3/2021/0556.

PWA Reference: 21-1101

**3/2021/0556 - 74 HIGHER ROAD, LONGRIDGE**

**APPLICATION FOR RESERVED MATTERS CONSENT (APPEARANCE, SCALE, LANDSCAPING AND LAYOUT) PURSUANT TO OUTLINE PLANNING CONSENT (REF: 3/2016/1082) FOR THE DEMOLITION OF 74 HIGHER ROAD AND CONSTRUCTION OF UP TO 123 HOUSES ON LAND TO THE REAR.**

ILLUSTRATIVE SITE SECTIONS - SHEET 1 OF 2

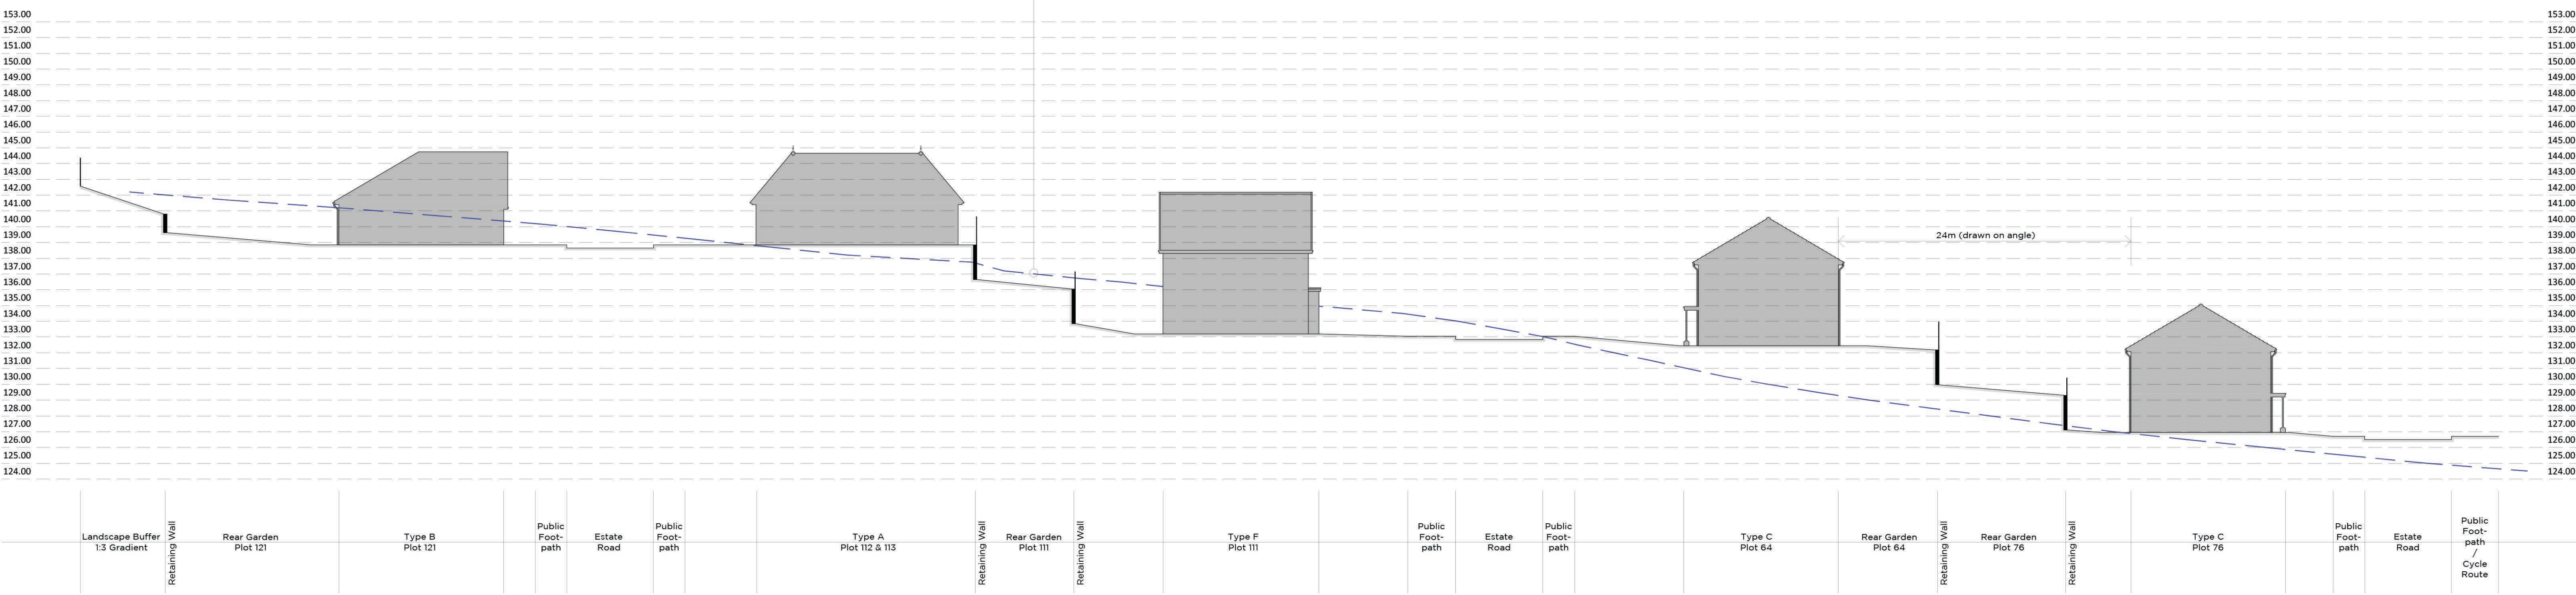
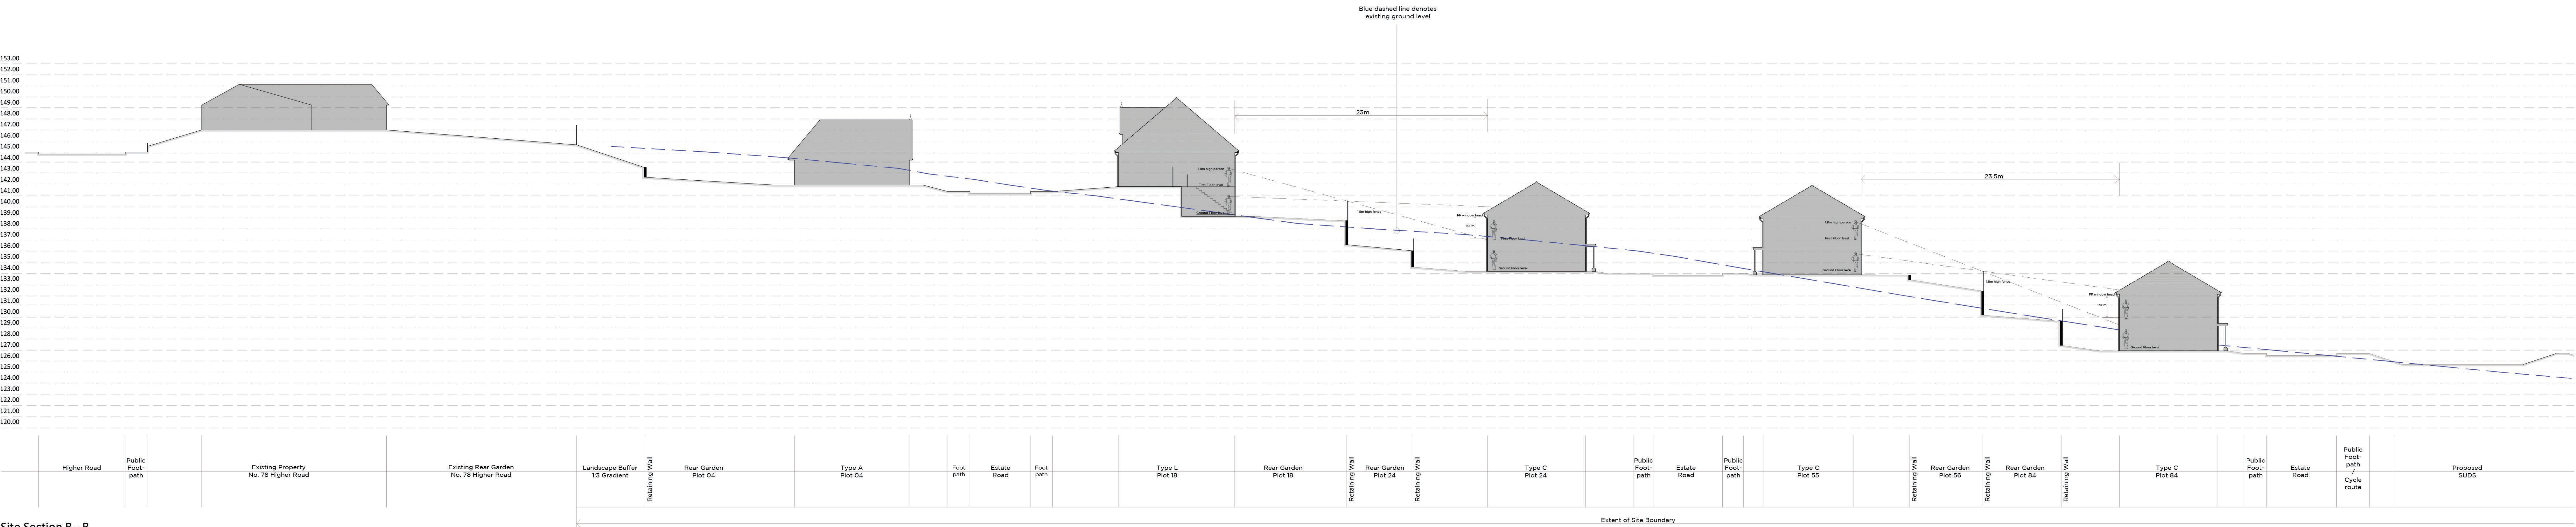
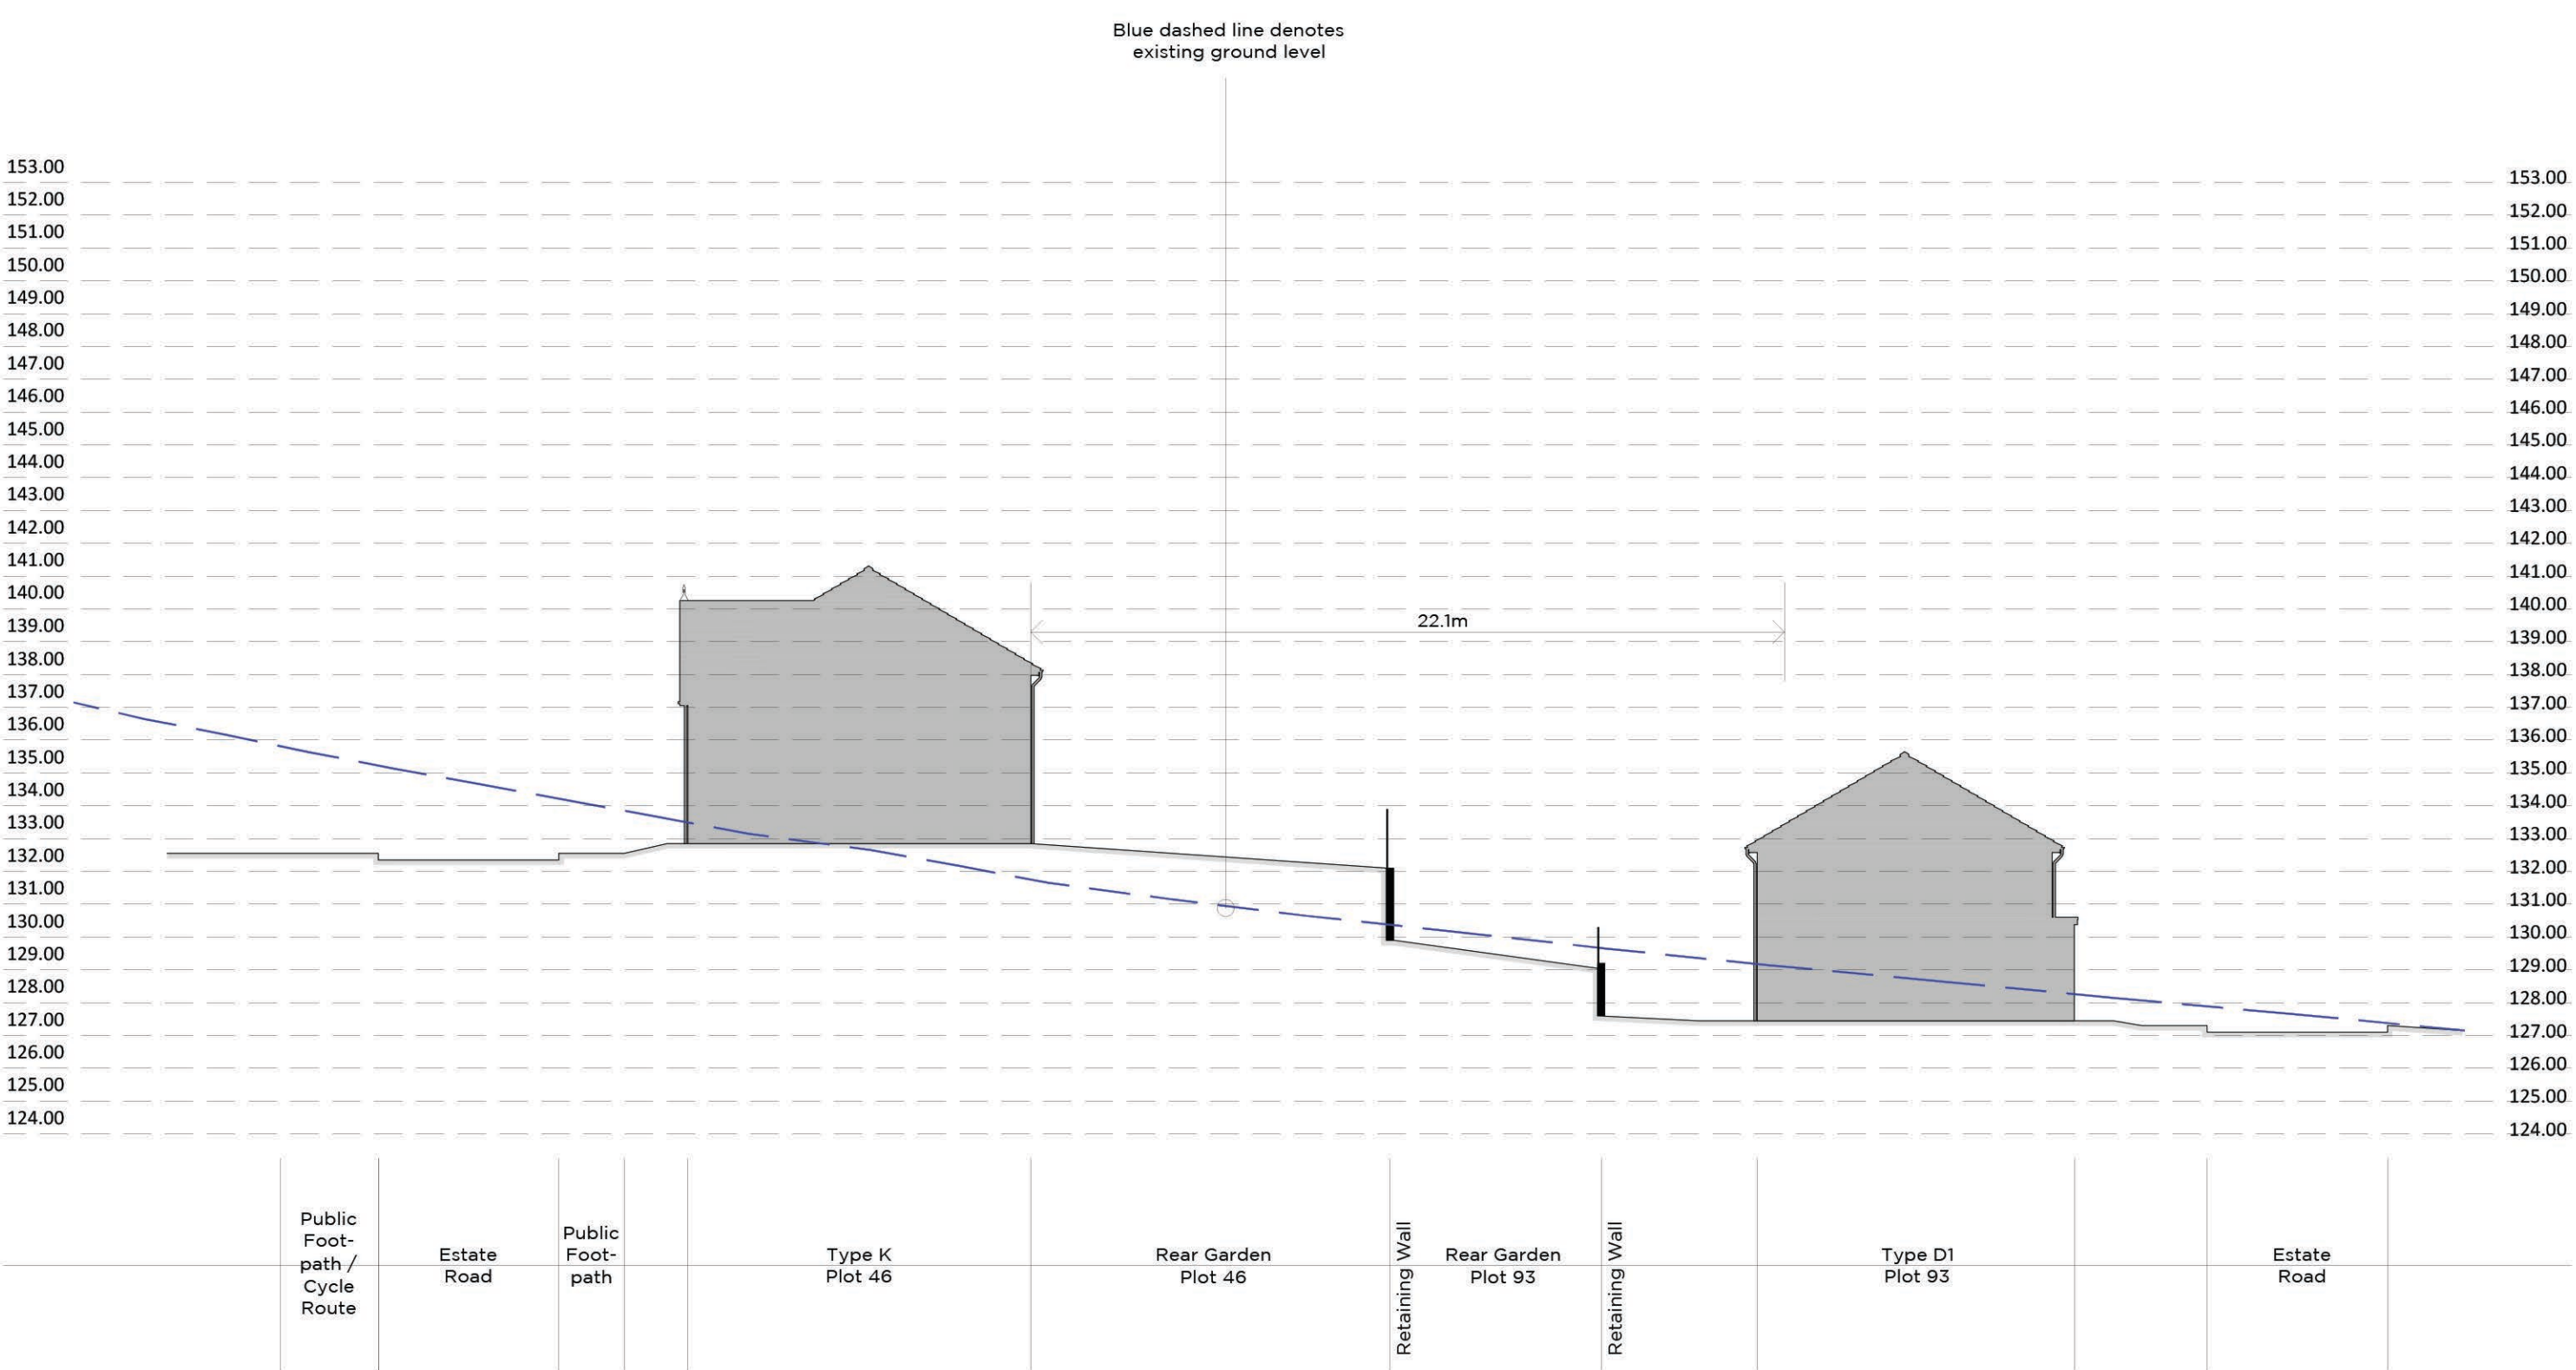
*I have no comments to make in relation to the individual house type designs. However, I have reviewed the engineering drawings/sections and the level changes between dwellings across the site are problematic. I understand that the topography of the site is challenging however I refer to the following plot numbers where retaining walls are of considerable height.*

- *Plots 105 -106: rw height of 4.5m*
- *Plots 74 -90: rw height of 3.75 -6.75m (level change between back-to-back dwellings would also require increase above 21 m due to diff in levels)*
- *Plots 91-103: rw height of 4.15m -5.6m (level change between back-to-back dwellings would also require increase above 21 m due to diff in levels)*
- *Plot 15: rw height of 4.25m*

- *Plots 23 -27 (level change between back-to-back dwellings would also require increase above 21 m due to diff in levels)*
- *Plots 28-30: rw height of 4.5m*

*It is further noted that these rw heights will generally be further increased by provision of 1.8m high fencing above. This leads to fundamental concerns regarding overbearing impact/enclosure within rear gardens that back onto retaining walls and significant level disparity between back-to-back dwellings. This will require a rethink regarding layout and/or level changes across the site.'*

To address your concerns, properties within the north-eastern / southern development parcels can be repositioned to improve interface distances which exceed policy requirements, as demonstrated on the attached illustrative site section drawing Ref: 20126\_06\_A.

Furthermore, all retaining walls have been reduced to a maximum of 2.2m high, which has ensured that no structure is over 4m tall even when fencing is included as requested. We have also undertaken a full review of FFLs.
